**From:** Ford PC [REDACTED]  
**Sent:** 17 April 2018 11:50  
**To:** Planning.Responses  
**Subject:** RE: Planning Consultation on: F/4/18/PL

**APPLICATION NO:** F/4/18/PL

**Site Address:** Land to the South of Ford Lane Ford BN18 0DF

**Description of Works:** Salt storage building, office building, parking & turning area & open storage areas for highways maintenance depot - This is a Departure from the Development Plan

Proposed Site Plan and Location Plan

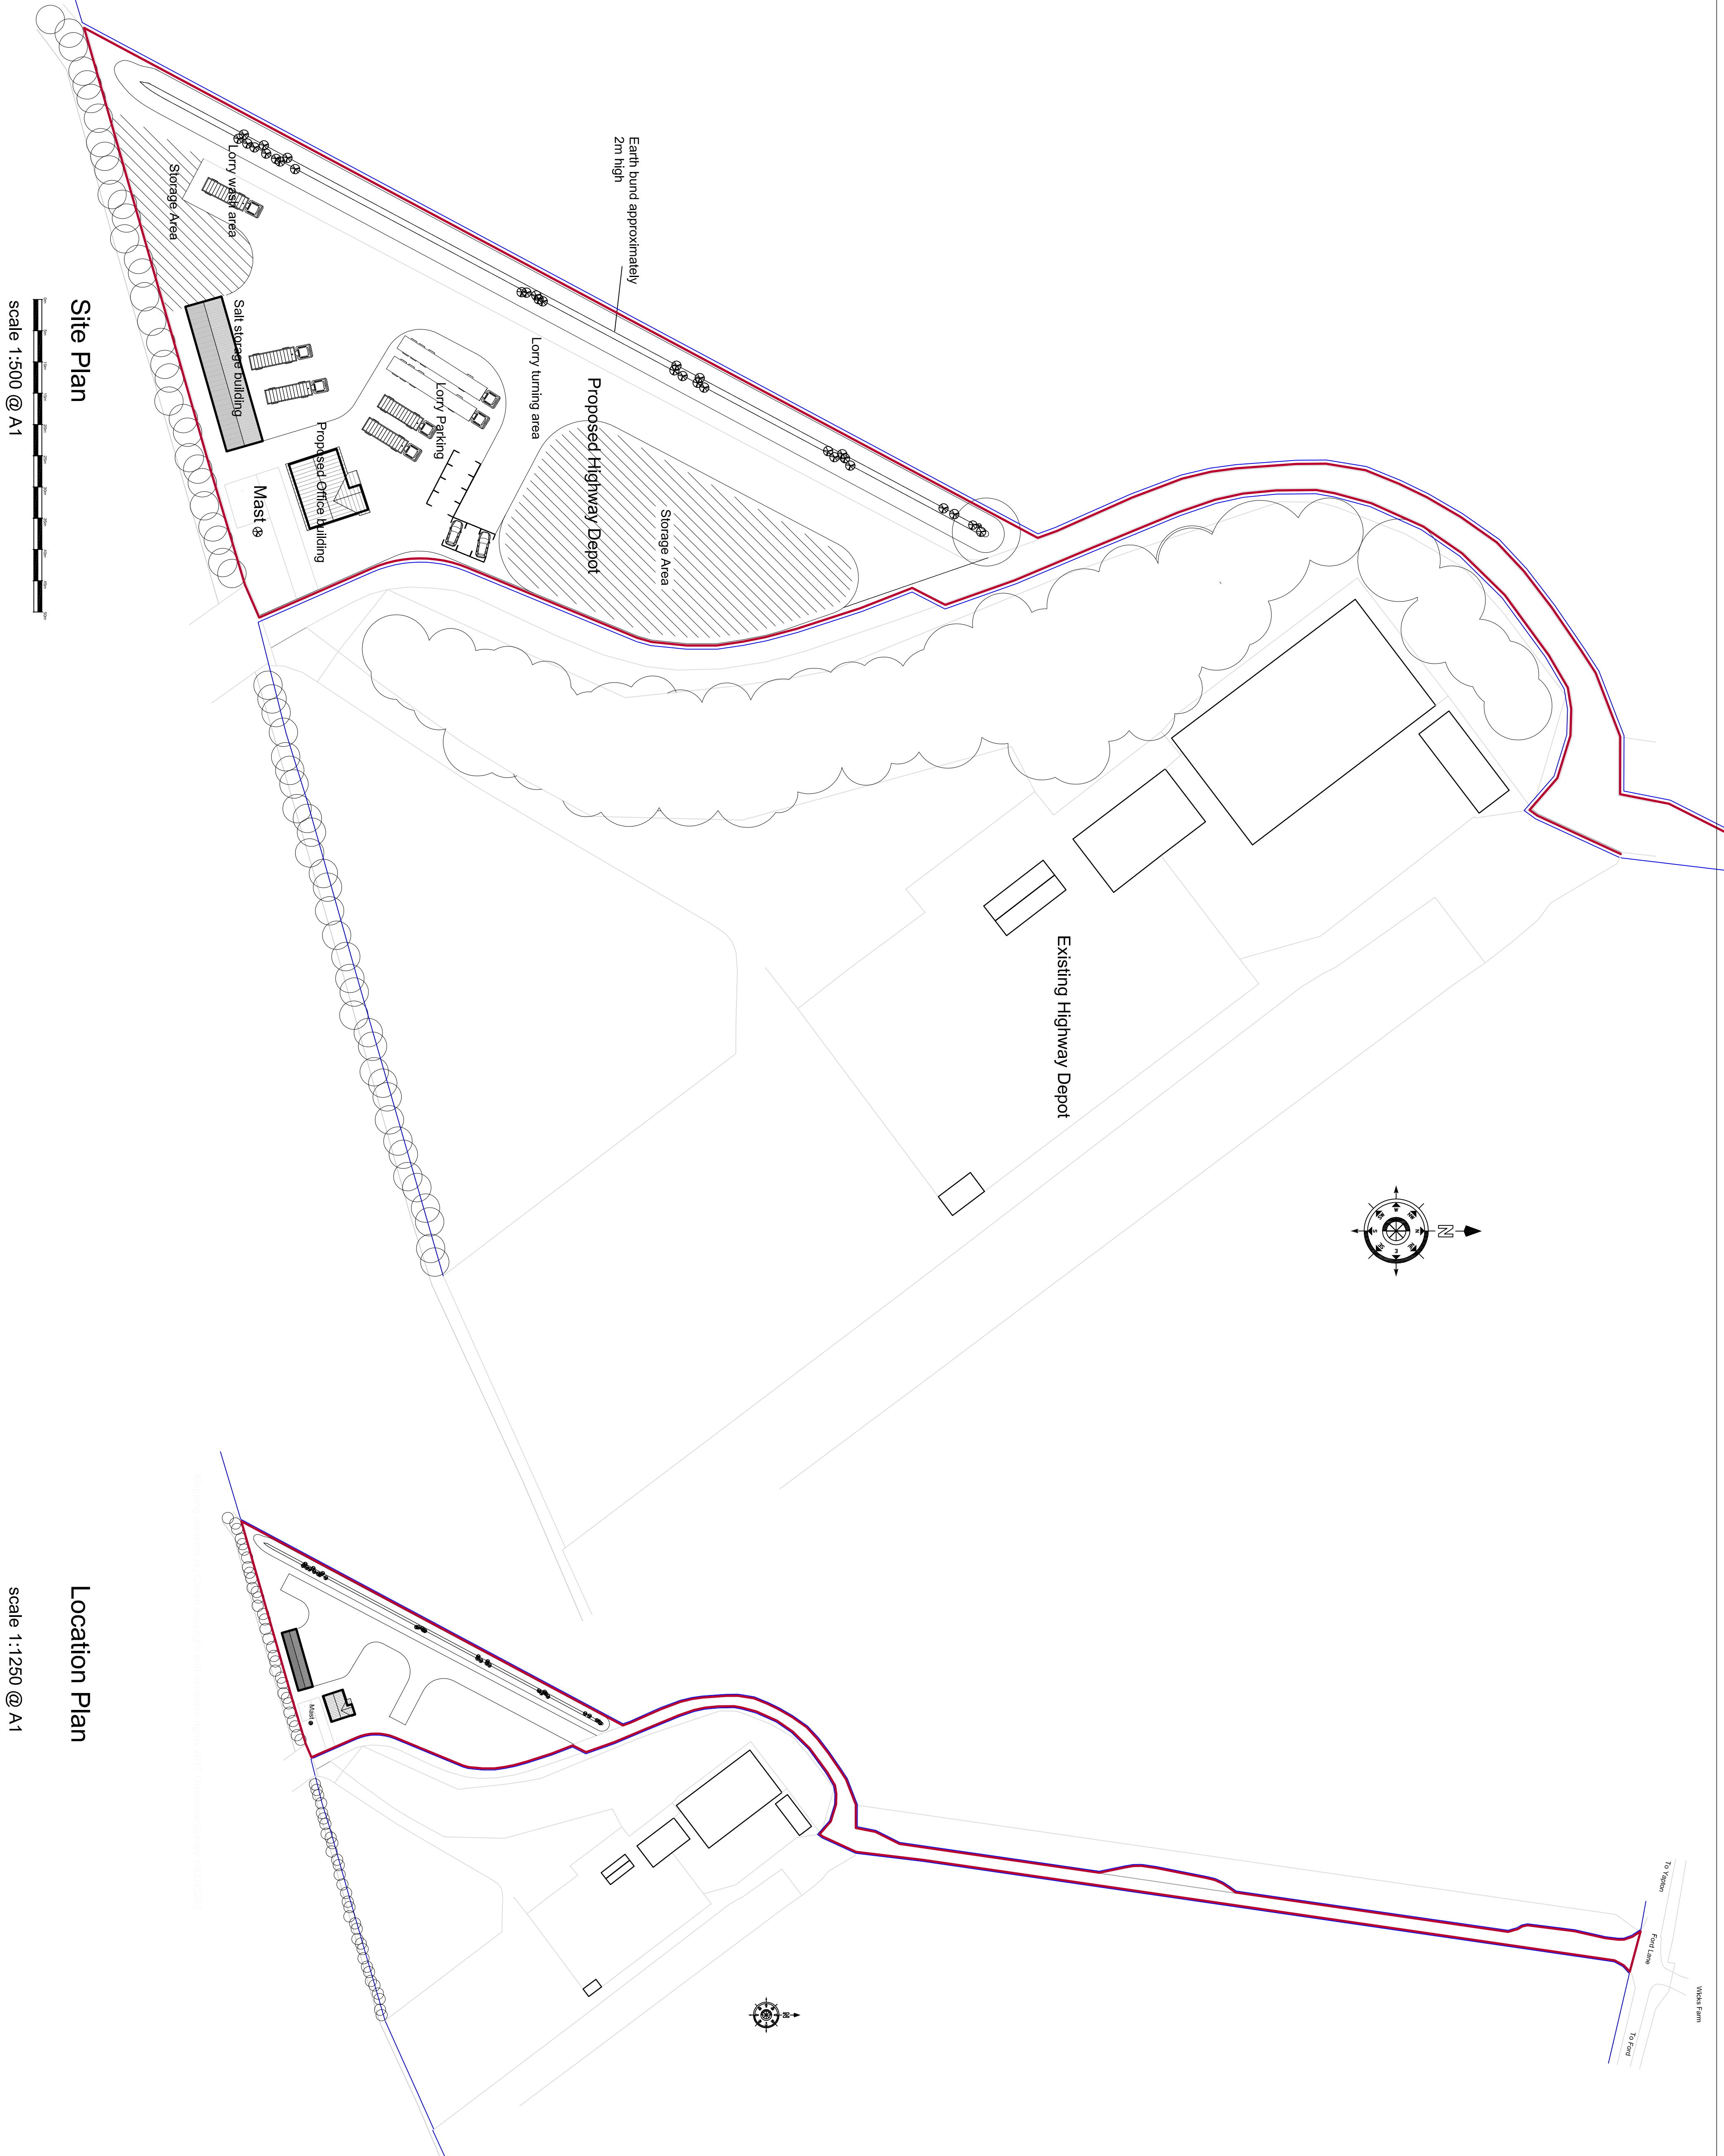
Ford Parish Council would like to ensure all traffic exits via Ford Lane entrance and no traffic takes a short cut and comes back to leave via Rollaston Park. The Council would also seek a condition that it is for the sole use of the Highways Agency for at least 5 years.
